From: Tim Townsend [REDACTED]
Sent: 24 January 2018 14:17
To: Simon Davis; Planning.Responses
Subject: RE: P/1/18/DOC - Application for approval of some matters reserved by planning condition - Land at 251 Pagham Road and Land R/O Pagham PO21 3QB - WSCC highway comments dated 22nd January 2018

From: Tim Townsend [REDACTED]
Sent: 22 January 2018 15:17
To: Planning.Responses
Cc: Dawn Hall; Simon Davis; Harvey Rogers
Subject: P/1/18/DOC - Application for approval of some matters reserved by planning condition - Land at 251 Pagham Road and Land R/O Pagham PO21 3QB - WSCC highway comments dated 22nd January 2018

REFUSE AND CYCLE STORE FOR APARTMENT BLOCK 1:50

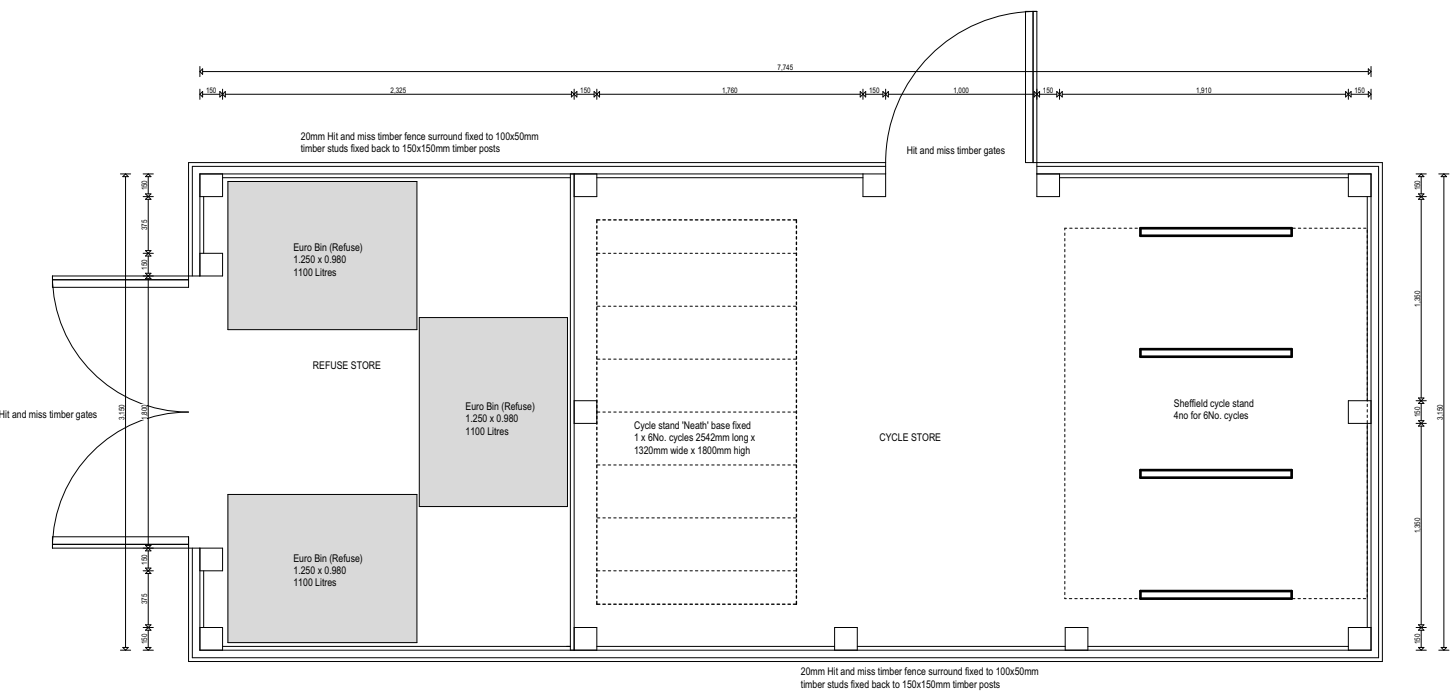
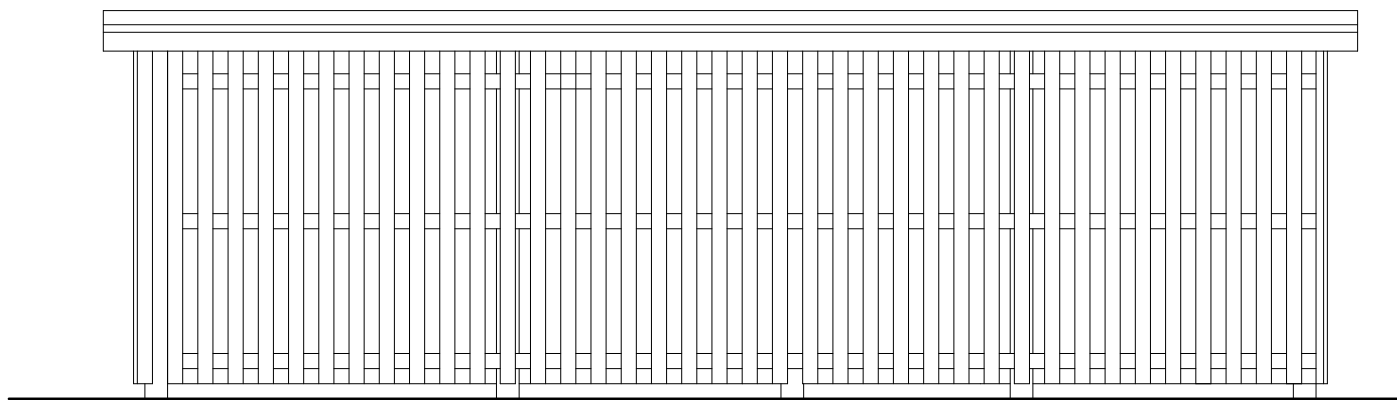
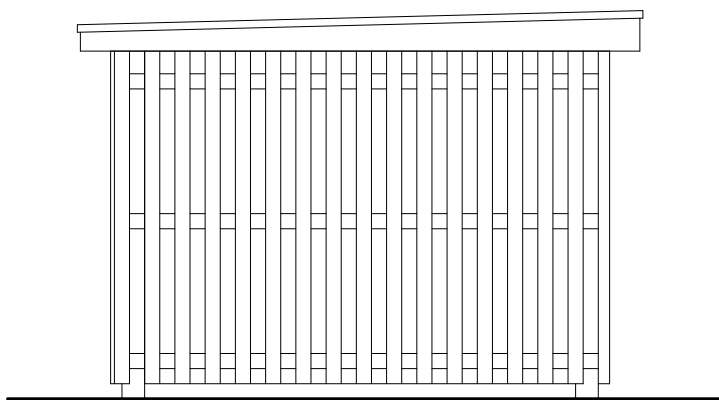
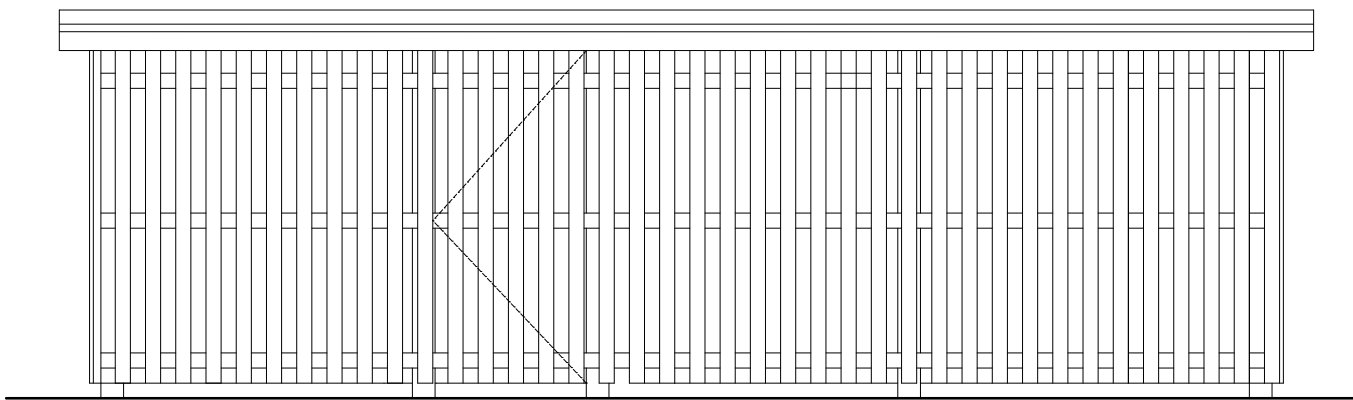
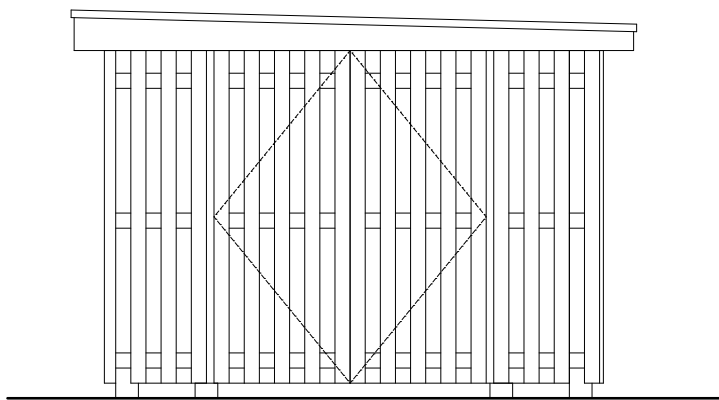
County recommend 'Sheffield Stands' as they cater better for all users - some of whom might not be able to push their bikes upright as-per the Neath version shown (the latter are normally chosen when lots of bikes have to be catered-for and also where space is tight - I don't think this is the case here although they would have to satisfy us that Sheffield's could be installed in such a way as they are then fit-for-purpose and can be used properly.

I recommend that you ask them to revise the type and demonstrate that they will be useable and accessible.
